Item No. **Report of the Head of Planning, Transportation and Regeneration**

Address 245 PARK ROAD UXBRIDGE

Development: Two storey front extension

LBH Ref Nos: **76478/APP/2021/2871**

SITE: 245 Park Road, Uxbridge. UB8 3NS	DRAWN:	SCALE:	DATE:
	DAE	1:50 @ A3	April 21
	DRAWING NO:	21/19/93	REV: A

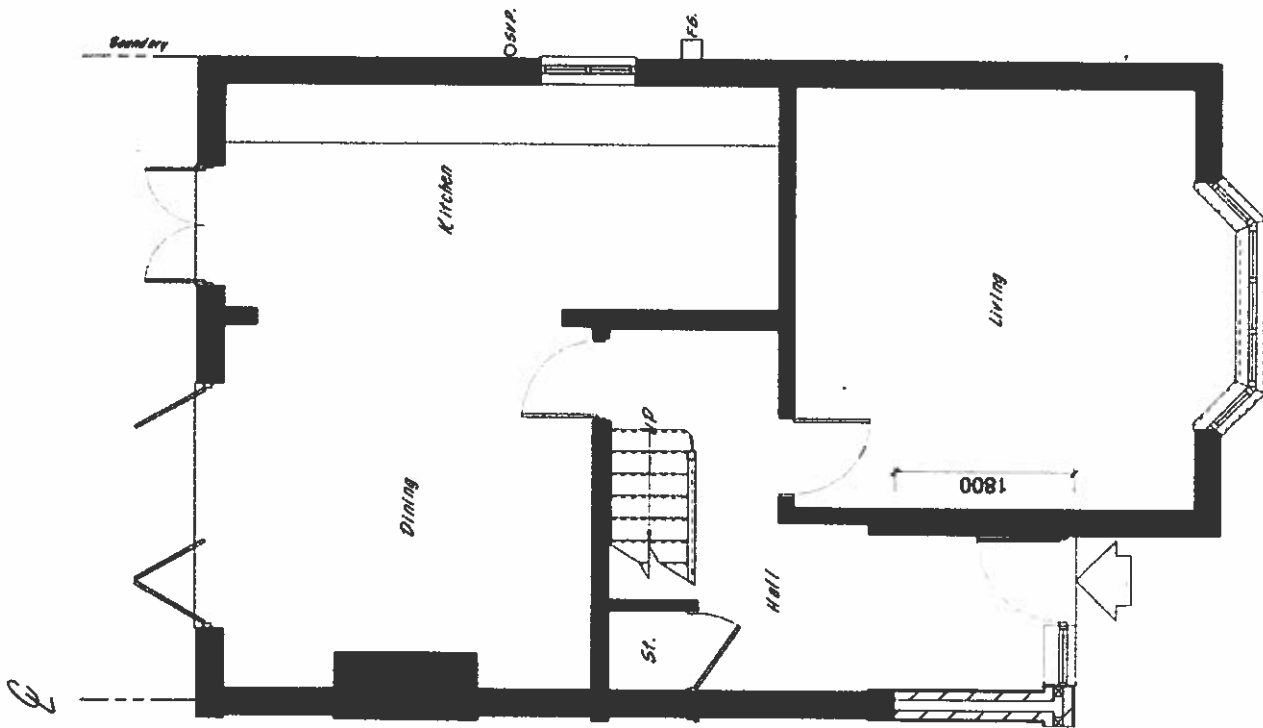
The proposal seeks permission for a two storey front extension would infill part of the the recessed section of the front facade. The extension would measure approximately 1.8 m in depth, 1.4 m in width and would be characterised by a pitched roof measuring 3.14 m. The two storey scale of the extension would be considered contrary to the principles of DMHD 1 which seek to ensure that extensions are modestly designed and subordinate to the main dwelling. The proposed extension would be visibly at odds with the design and appearance of the subject building, forming an illogical and alien addition to the front of the property. Furthermore the crown roof design would be inappropriate and would result in a roof form which is at odds with the character and appearance of the street scene and the architectural composition of the existing property. Whilst it is noted that the an application for the same development at No 245 has been submitted this proposal would result in an imbalance of symmetry between the two properties if the application at No 245 were not to be implemented.

SITE: 245 Park Road, Unbridge, UB8 3NS	DRAWN:	SCALE:	DATE:
	DAE	1:50 @ A3	April 21
	DRAWING NO:	21/191/94	REV: A

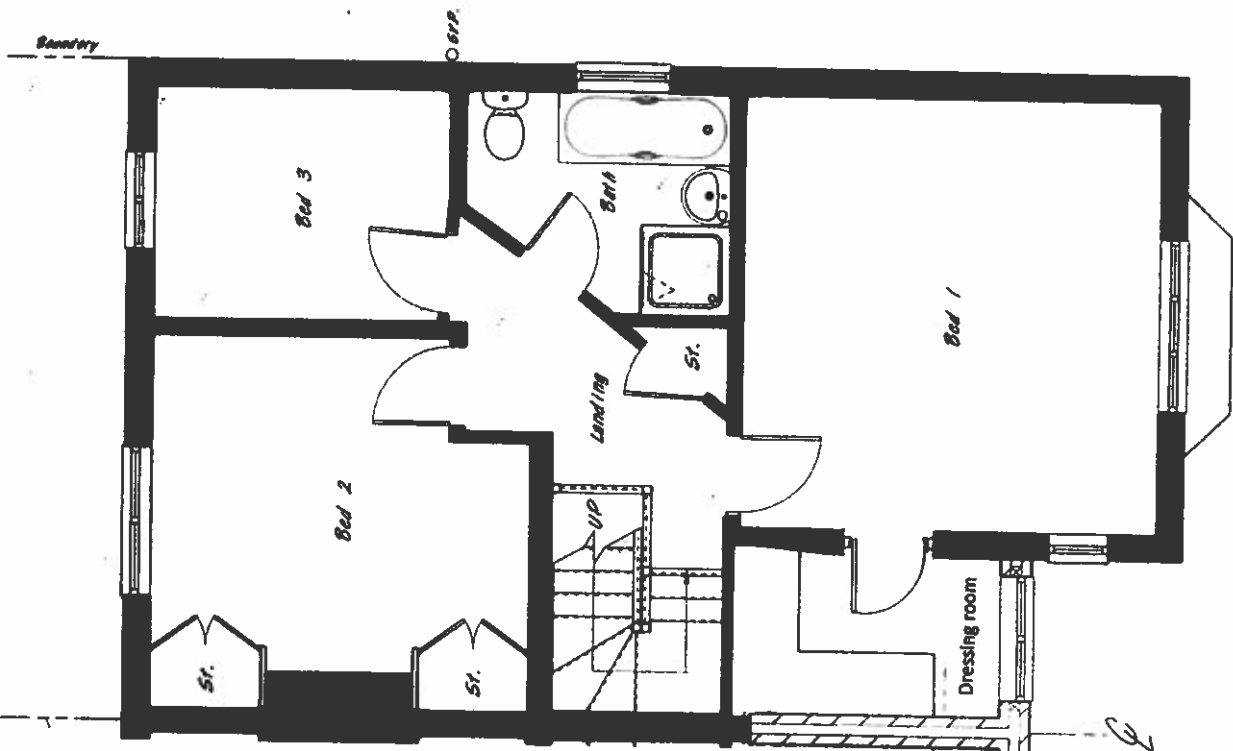
No.243 is the adjoining property which forms the pair of semi's and is therefore the principle property which needs to be considered. Both properties feature a recessed section in the front elevation which would be infilled by the proposed extension. Whilst when viewed in isolation the proposal would extend beyond the recessed section of the front elevation of neighbouring property this would extend beyond the door and the window which serves the hallway above the door. There would be no material loss of light or outlook.
